**WELWYN HATFIELD COUNCIL – DEVELOPMENT CONTROL**  
**DELEGATED REPORT**

<b>APPLICATION No:</b>	<b>S6/2009/2749/FP</b>
------------------------	------------------------

The application seeks full planning permission for the 'erection of a two storey residential extension, first floor granny annexe and B1 (office) replacement following demolition of existing ground floor offices.'

EAST ELEVATION
SCALE 1:100

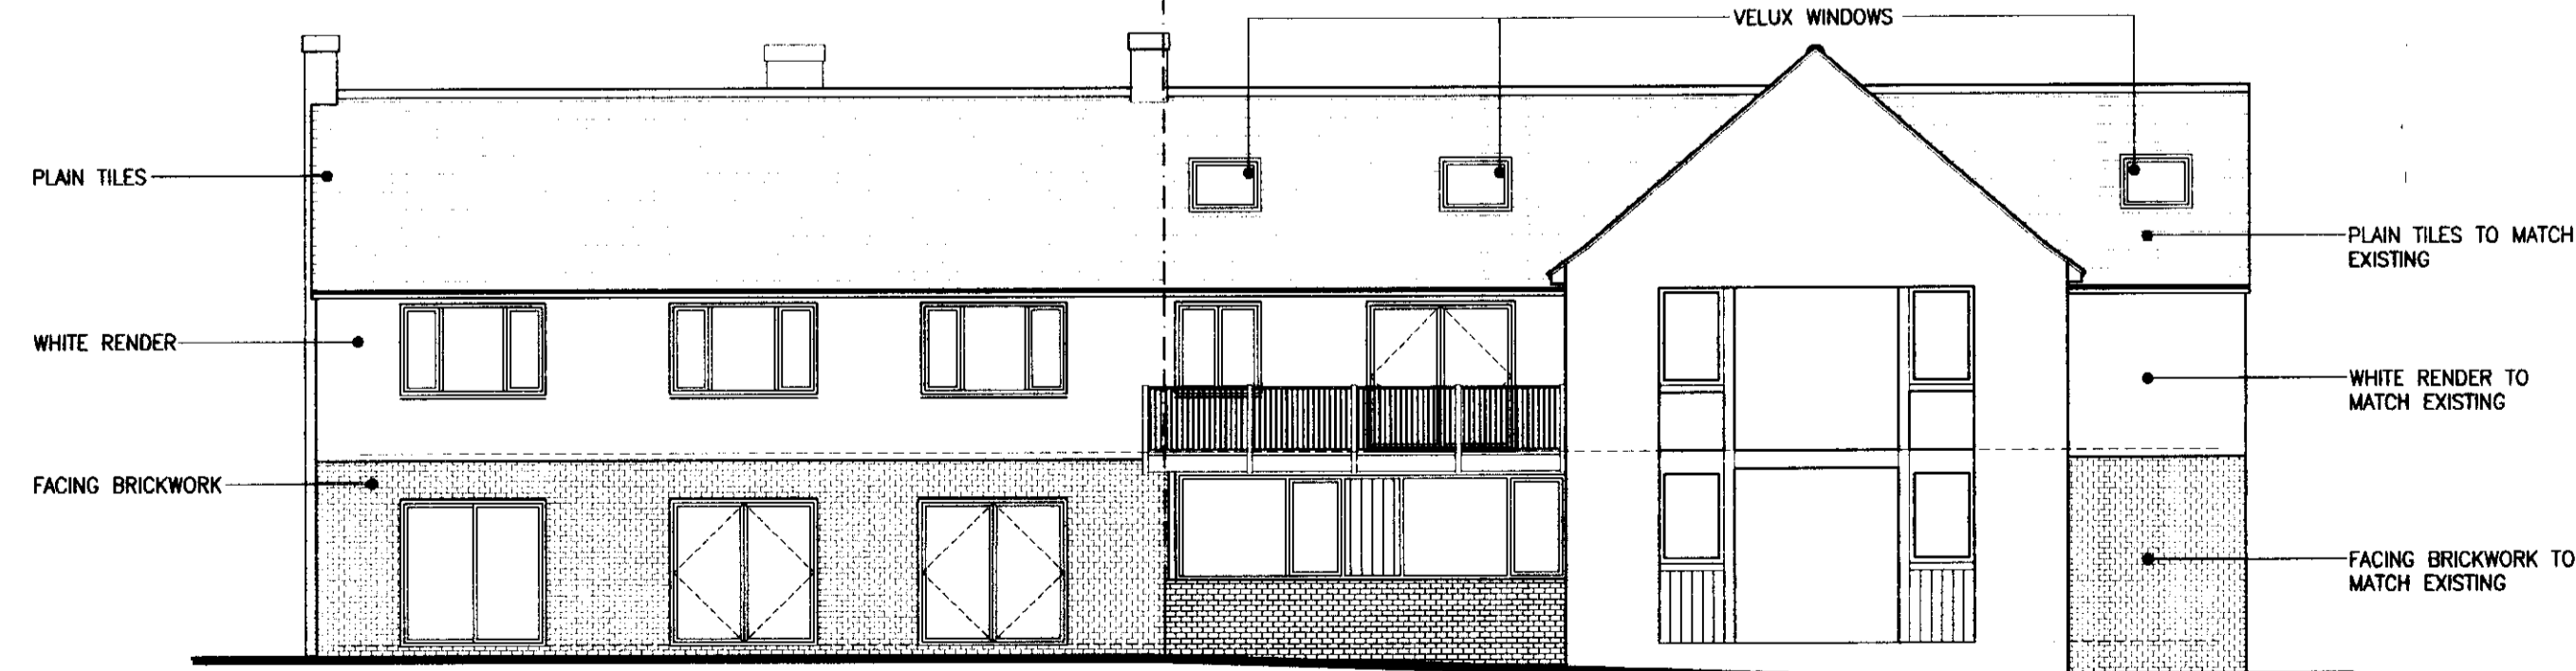
The proposed new resultant floor areas comprises approximately 174 sqm at ground level and approximately 228 sqm at first floor level giving an overall resultant floor area of approximately 402 sqm. This would result in an overall increase in new habitable residential floor areas since the 'original dwelling was built of 250 sqm which is approximately 164 % increase of floor area compared to the 'original' dwelling.

would not increase the height of the 'original' dwelling, but would add significantly further to its overall mass. Although the east side of the dwelling would remain in its existing form, the resultant building would increase significantly to the west with the proposed two storey extensions. This increase in mass along with the increase in habitable floor areas of 164% would result in a disproportionate addition over and above the size of the 'original' dwelling. The proposal is therefore considered to represent inappropriate development in the Green Belt. The proposal would fail the requirements of Criteria (i) of Policy RA3 and also PPG2.

- 1. The cumulative effect of the proposed development would, when considered in relation to previous extensions to the dwellinghouse, result in disproportionate additions over and above the size of the original dwelling due to the increase in the resultant floor area, size, bulk and mass. This would significantly reduce the openness of this part of the Green Belt to the harm of the rural character of the area contrary to the requirements of Policy RA3 of the Welwyn Hatfield District Plan 2005 and Planning Policy Guidance Note 2 (Green Belt). There are no very special circumstances which have been advanced to justify a departure from the Green Belt Policies of restraint.
